**Yarren Hut Solar Farm (SSD 10415)**

Thank you for your request dated 12 August 2020 to the Biodiversity and Conservation Division (BCD) requesting advice on the Yarren Hut Solar Farm project (SSD 10415).

BCD has reviewed the biodiversity development assessment report (BDAR) for the project. BCD's biodiversity recommendations are provided in **Attachment A** and detailed comments are provided in **Attachment B**.

Site Layout

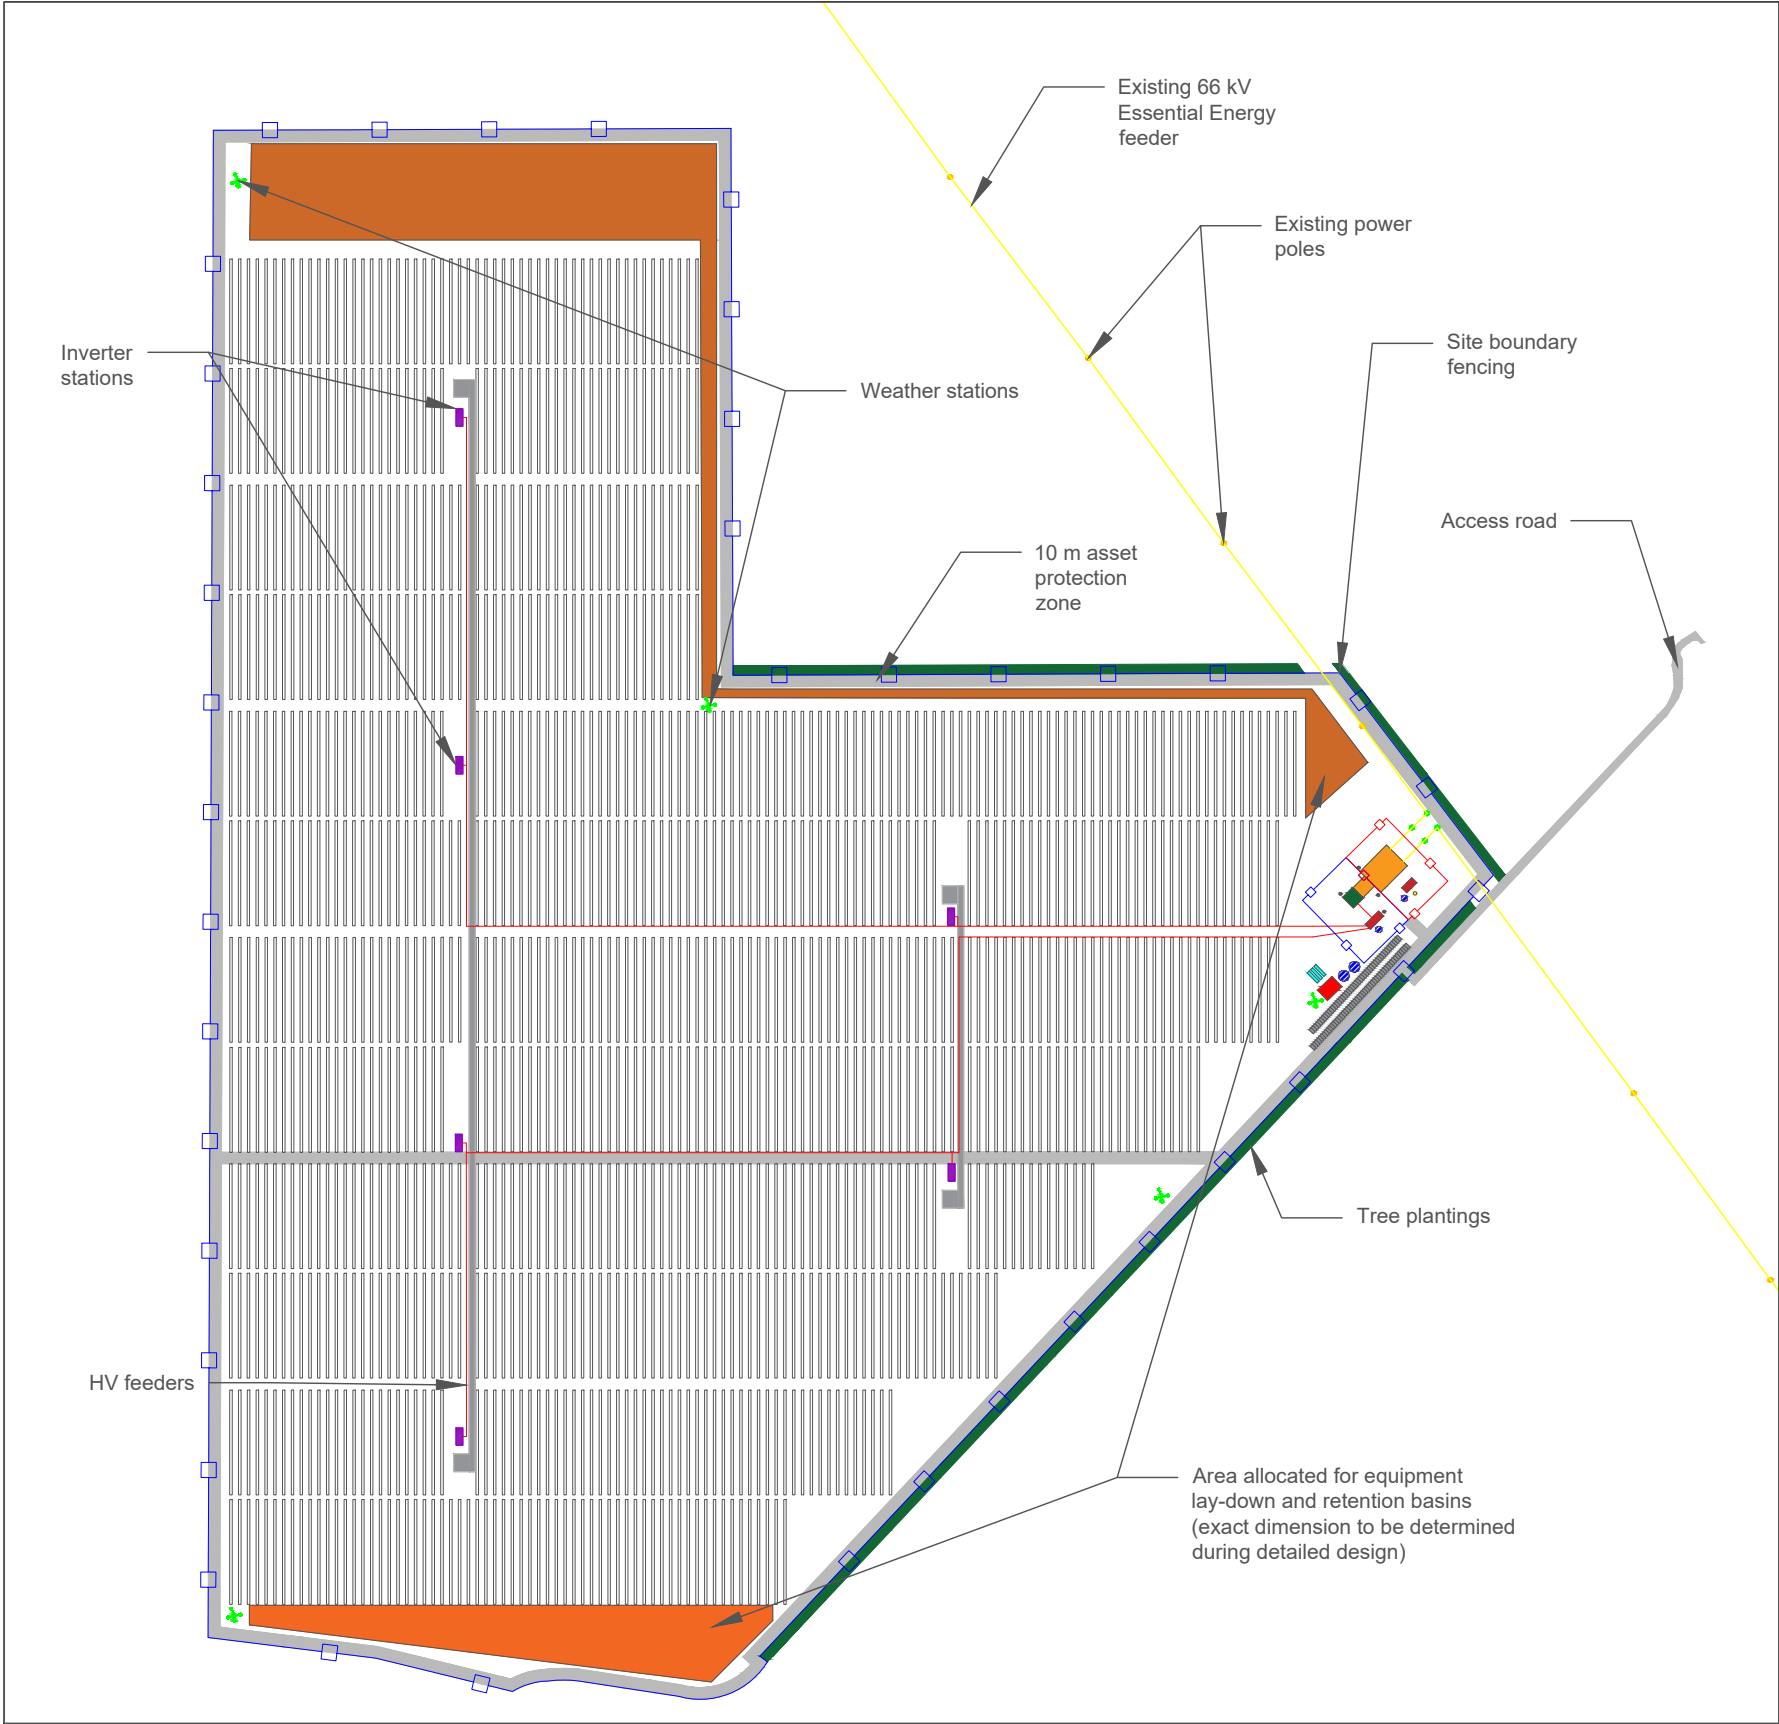
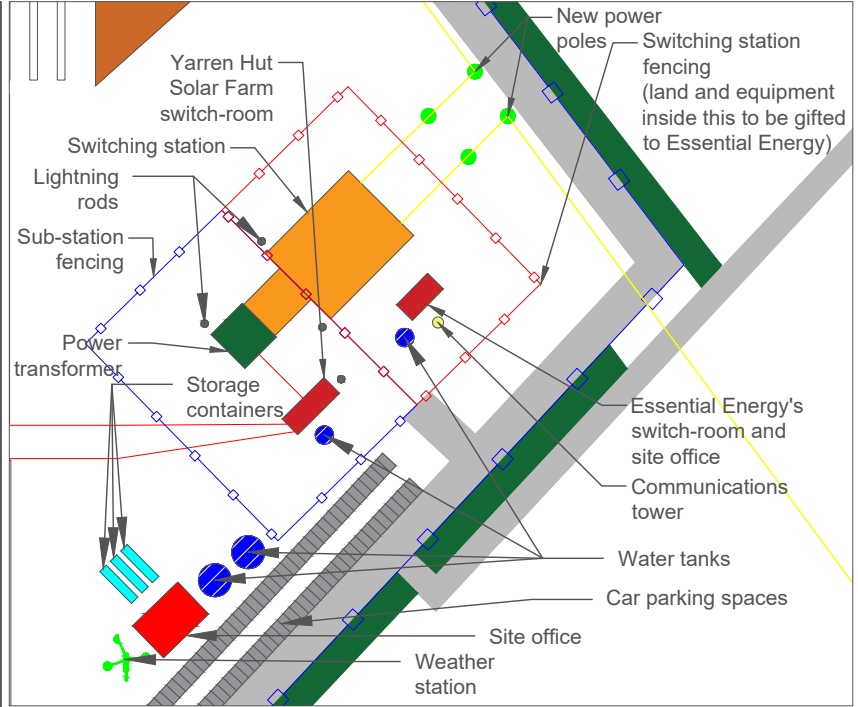
The scale of the maps presented and some apparent conflict between them has made it difficult to verify the exact location of the 'access treatment' portion of the development footprint and the impact of the access area on native vegetation and habitat elements. Clarification of the footprint via a definitive map at an appropriate scale, habitat assessment results and adequate photos of this area will assist in addressing the comments and recommendations provided in this attachment.

Two example maps (Figure 3-1 and 6-1) from the Biodiversity Development Assessment Report (BDAR) are provided below. They appear to show two different alignments for the access treatment. The alignment shown in Figure 6-1 appears to conflict with that shown in the remainder of the maps in the BDAR.

The map below shows the access treatment, site layout and recorded trees shapefiles provided to BCD by NGH. Despite checking the datum and projection of all layers, it appears there may be an issue in alignment of the files and the aerial image. Nevertheless, it appears the footprint shapefiles align with Figure 6-1 above but not the remainder of the maps in the BDAR.

Furthermore, it appears that the BAM plot established was located adjacent to, but outside of the development footprint. No plot data is provided from within the area of impact associated with the access treatment.

- a) a clear map at an appropriate scale which confirms the proposed location and extent of the footprint associated with the access treatment, correctly aligned with an aerial image. The polygon showing the footprint should be outlined only, with no shading.
- b) multiple photographs across the access treatment footprint to confirm the nature of the vegetation and structural elements in that area.
